From: Laura Gibbons
Sent: 11 April 2019 13:26
To: Planning.Responses
Cc: Andrew Wood
Subject: RE: Please find attached amendment on planning application Ref: FG/220/18/PL

Engineers Comments Regarding Surface Water Drainage

APPLICATION NO: FG/220/18/PL

Site Address: Land adjacent to Elm Lodge Tamarisk Way Ferring BN12 5ER

Drawing Title **PROPOSED POND ACCESS
PLAN**

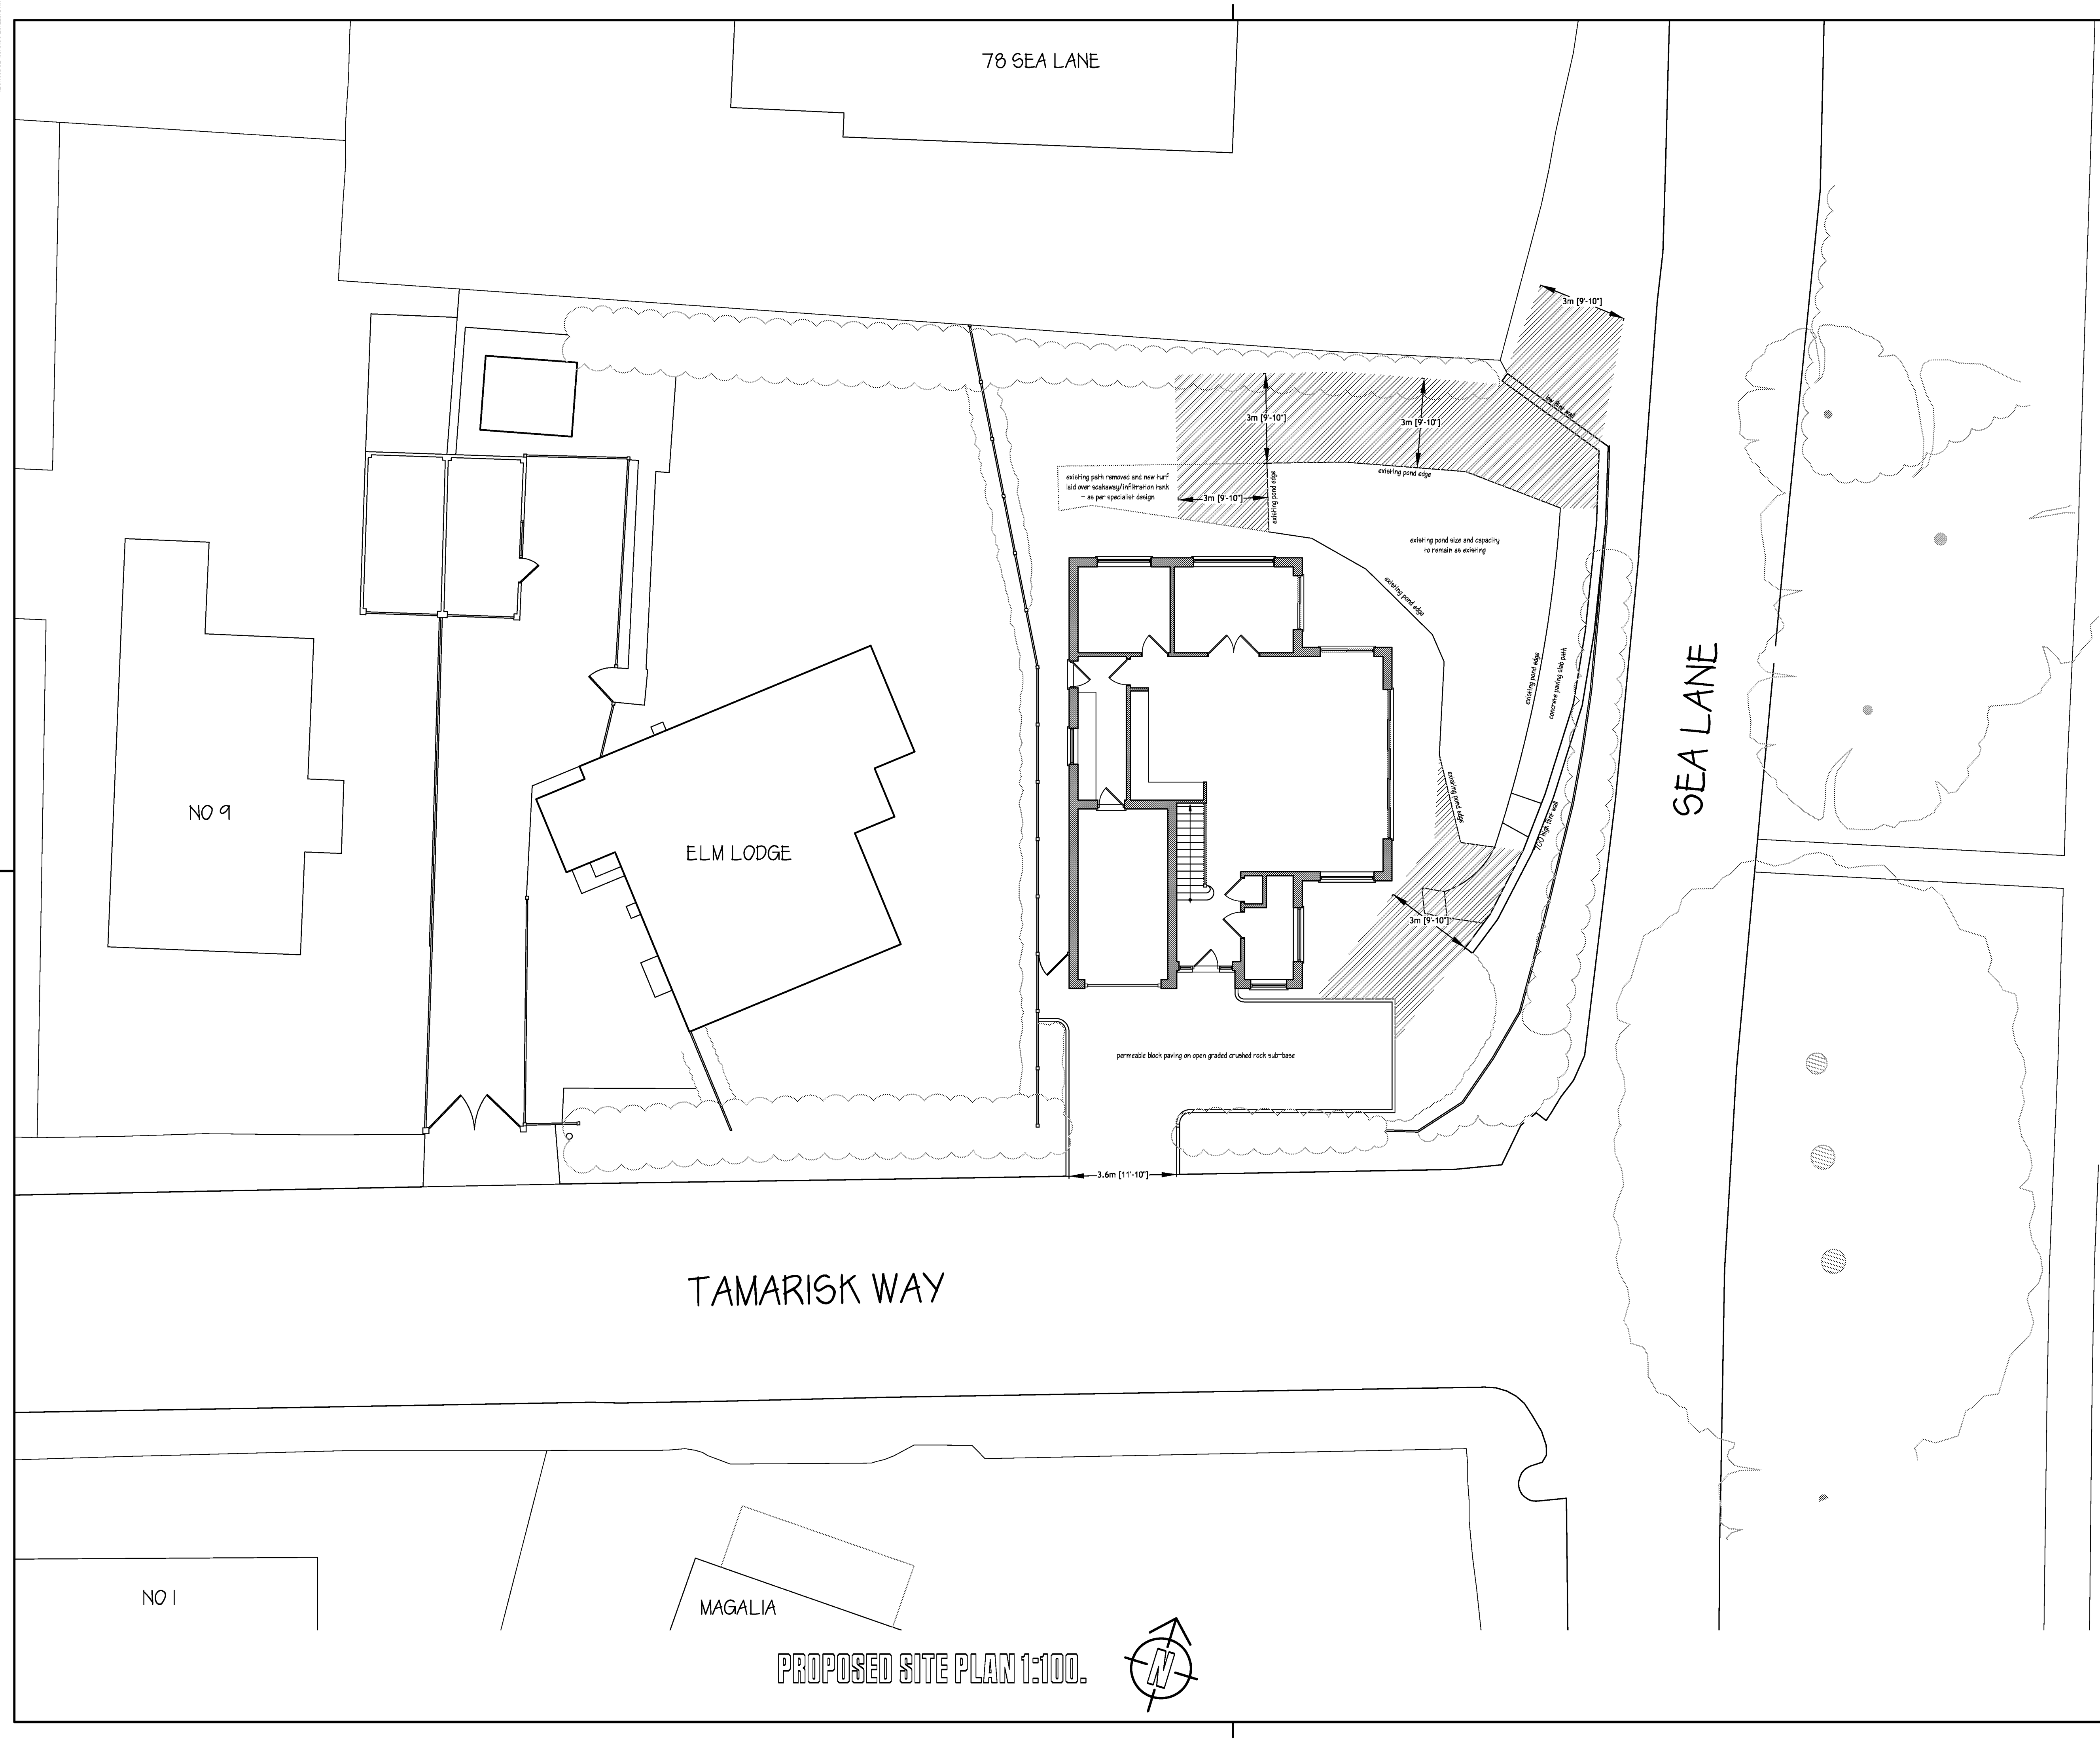
The proposed plans have been revised to provide easement to the pond to facilitate future maintenance works. The proposals have also been adjusted to remove the proposals for any infilling of the pond. I therefore remove my previous objection and request that should this application be approved the following conditions are applied.
